Application for a non-material amendment following a grant of planning permission.

Single storey rear extension with balcony above, single storey garage extension with replacement porch and new lean-to roof replacing existing flat roof, replacement pitch roof to existing flat roof over side two storey structure.

FG/03/09

CHANGE TO FRONT PORCH DESIGN

SHEET TITLE
SUBSTITUTION DRAWINGS (MINOR AMENDMENT) FOR PORCH DESIGN APPROVED UNDER FG/3/09

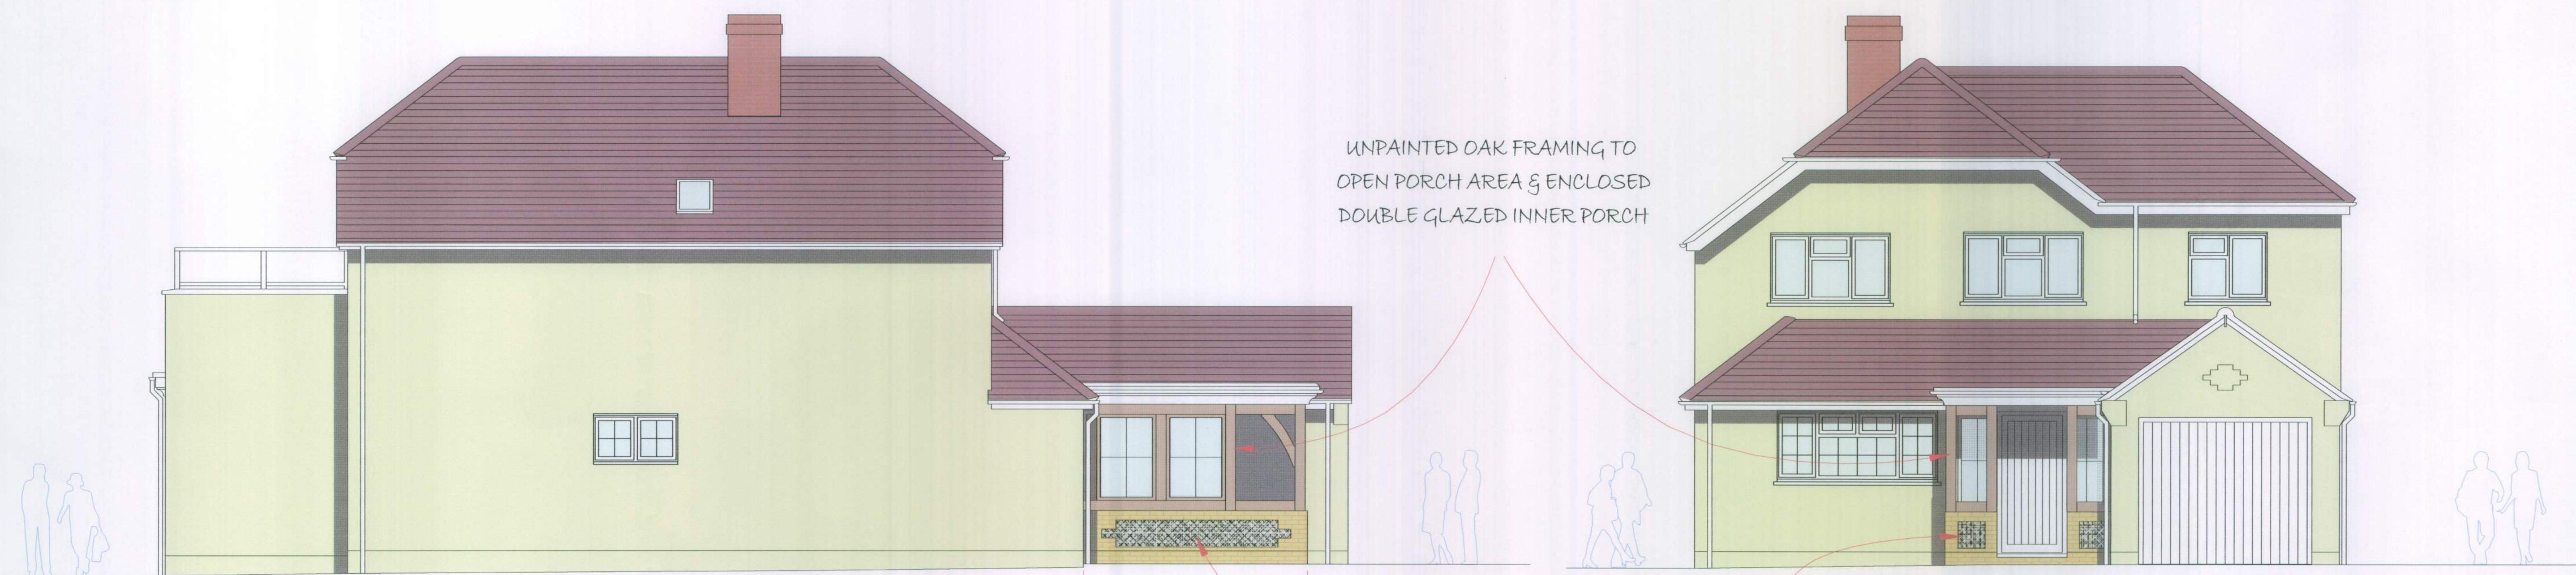
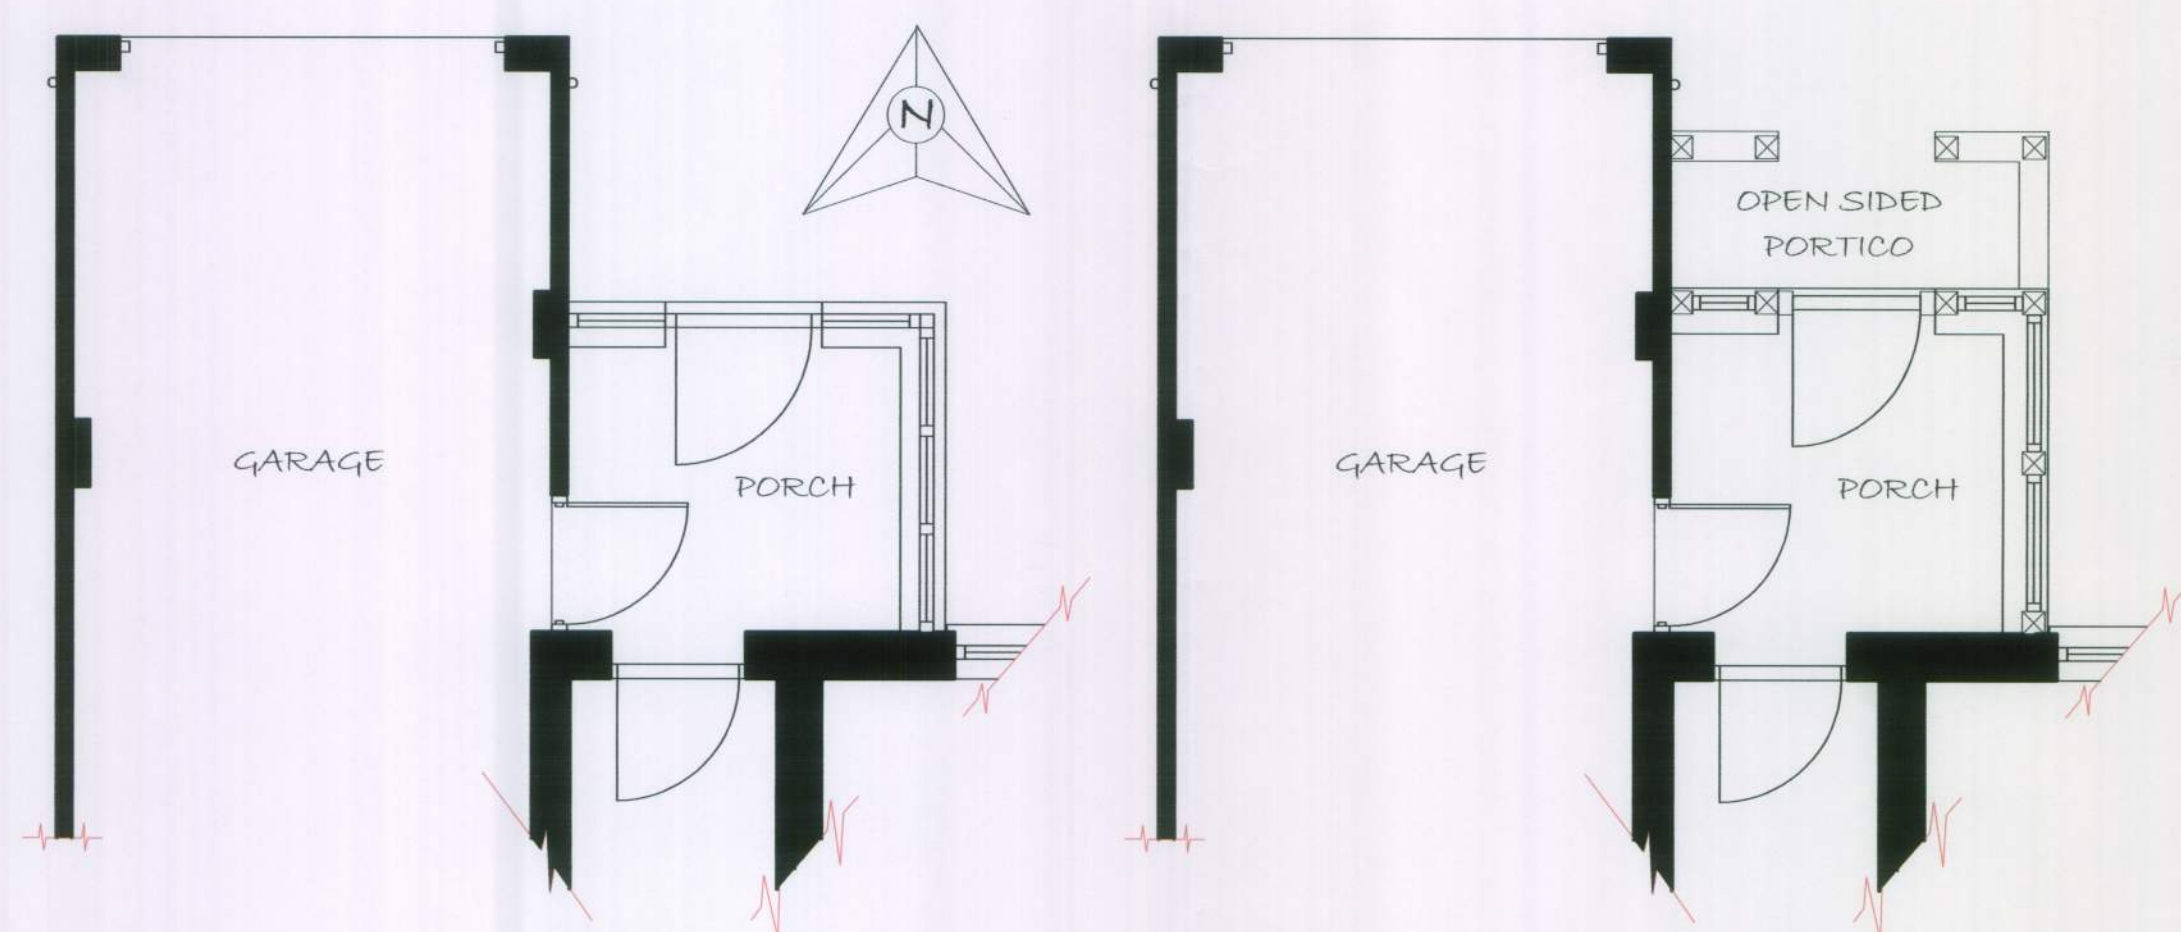
APPLICANT WISHES TO CHANGE ORIGINAL DESIGN TO PROVIDE AN OAK FRAMED STRUCTURE WITH WEATHER SHELTER FOR CALLERS
